CITY OF PORTLAND

September 2, 2004

RE: 199 Hope Avenue: Wetland Encroachment

NOV - 5

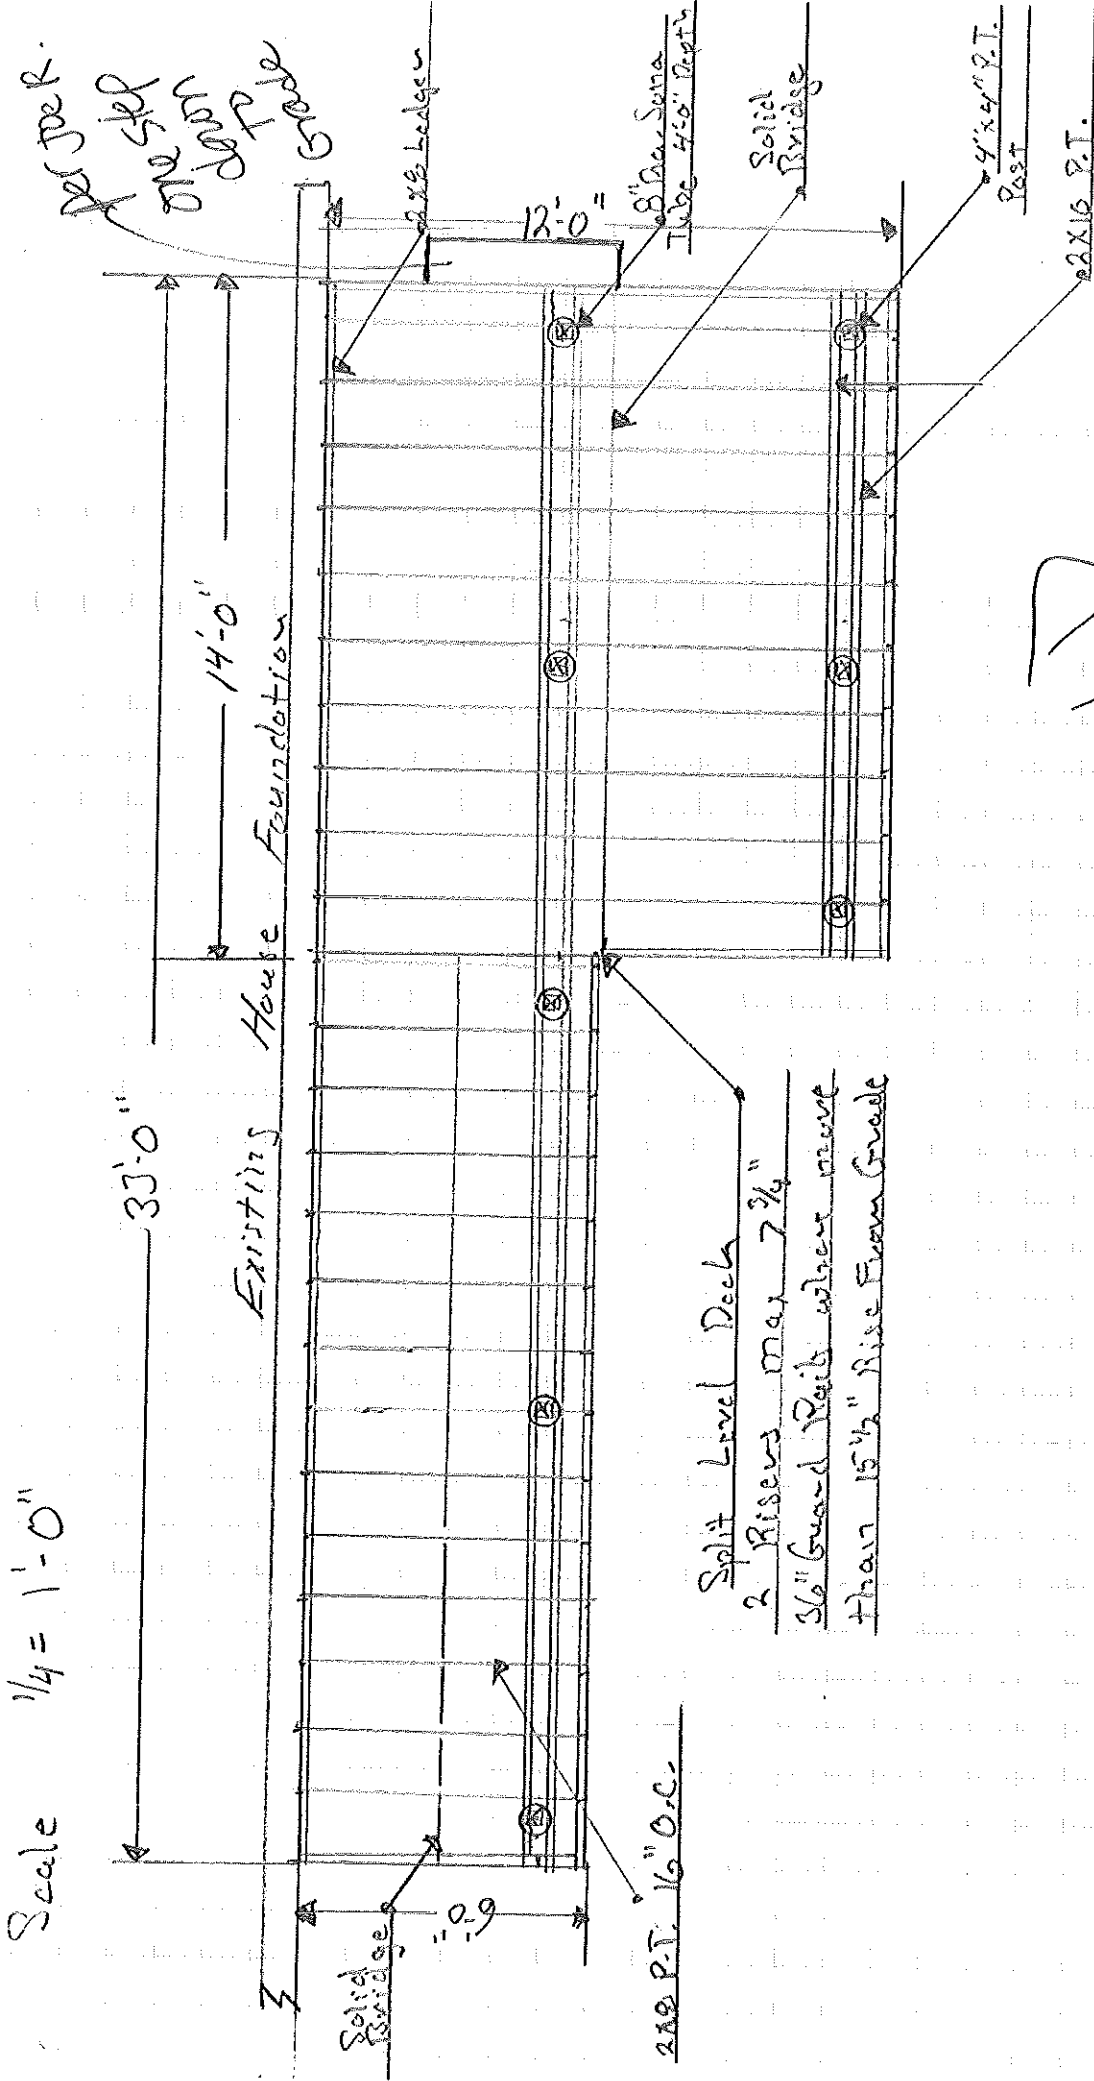
Once items 1 and 2 are completed, the City will be in a better position to evaluate the deck's permit application.

Also, the proposed deck falls outside of the building envelope. Certain lots in this subdivision require additional approvals to build outside of the building envelope. I will discuss this with our development review team to determine if this is required, and if the City would grant such a request.
